Ref: WA/48/14/PL

Demolition of existing commercial buildings/garages and erection of 3 No 2 bed terraced dwellings along with provision of ancillary parking, turning and landscaping (re-submission of application WA/52/13).
At Deans Yard Orchard Way Fontwell.

Proposed Site Layout

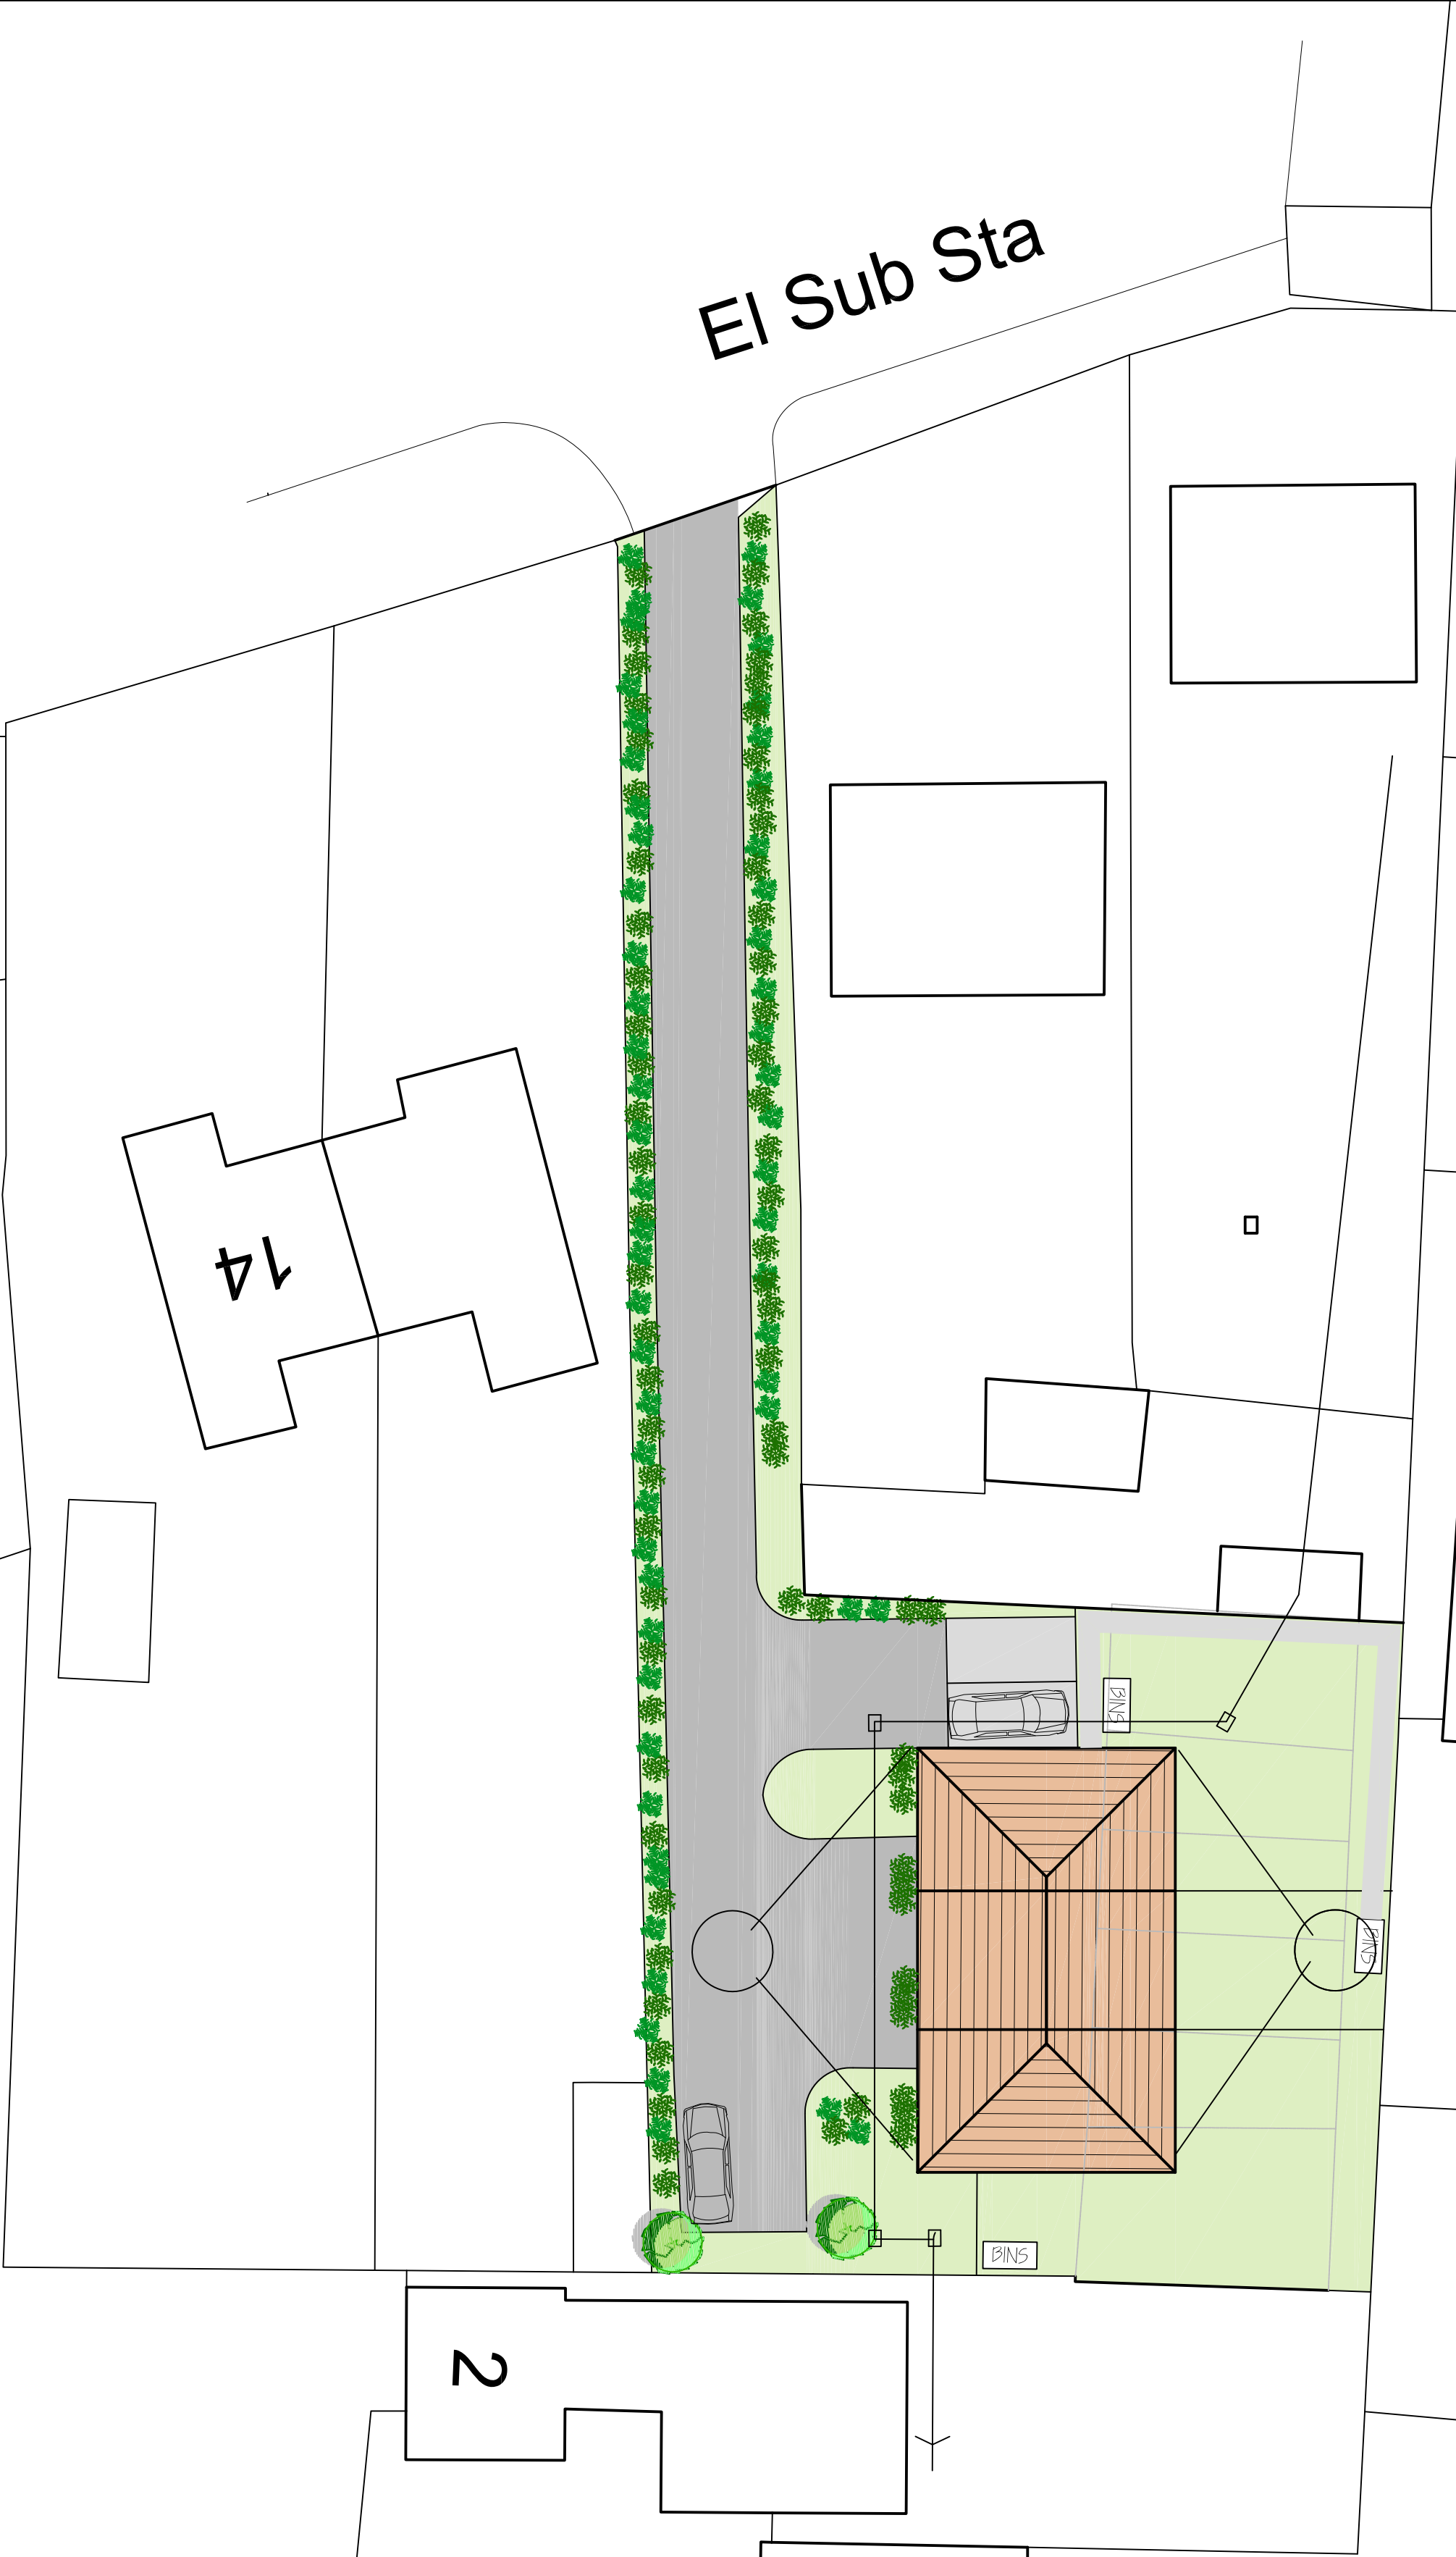
According to the latest Design and Access Statement it appears that the applicant has done nothing more than to move the terrace block to a more central position on the site to elevate the cramped boundary situation to the south affecting 2 Deans Close. All this effectively does is to make it more cramped to the north of the site encroaching more on the gardens of 18 and 20 Orchard Way.

The last point that we would like to make is that on the plans it shows an area for parking at the end of the access road to Deans Yard. This is not the Applicants land to commandeer for parking as this stretch of road belongs to Geoffrey Hudson Dean, (See previously submitted documents) and should not be included in the square footage for the development. We are very concerned about lack of space on the site for parking and access for services such as dustcarts and emergency vehicles. There just is not enough room for three houses and all that goes with them.

Proposed Layout & Elevations

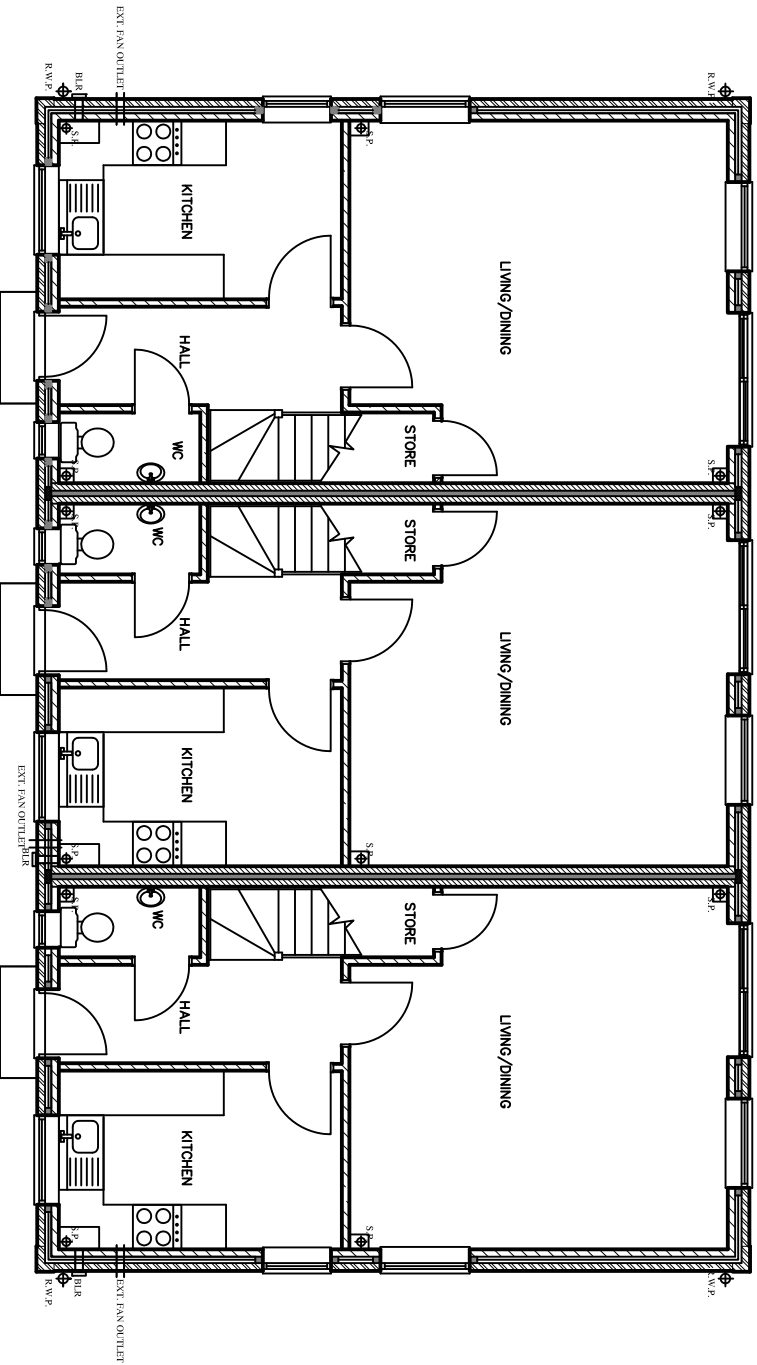
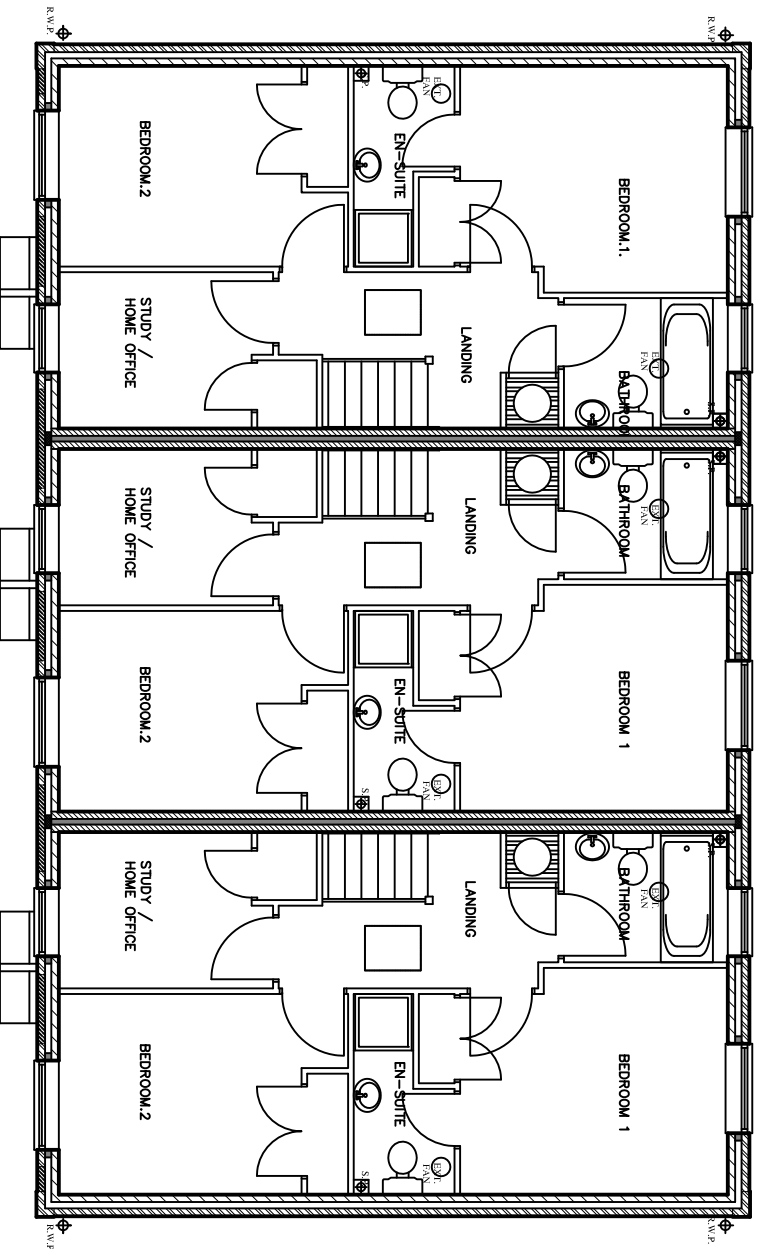
The other alteration that has been made is a change of wording on the floor plans, so instead of having "Bedroom 3", it states "Study/Home office". It then goes on to state in the D&A Statement that "if so required the stud wall between bed 2 and the home office could be removed to produce one larger double bedroom. It is incomprehensible to think that a new home is being built with the view to knocking down walls because the rooms are too small and basically not fit for purpose!
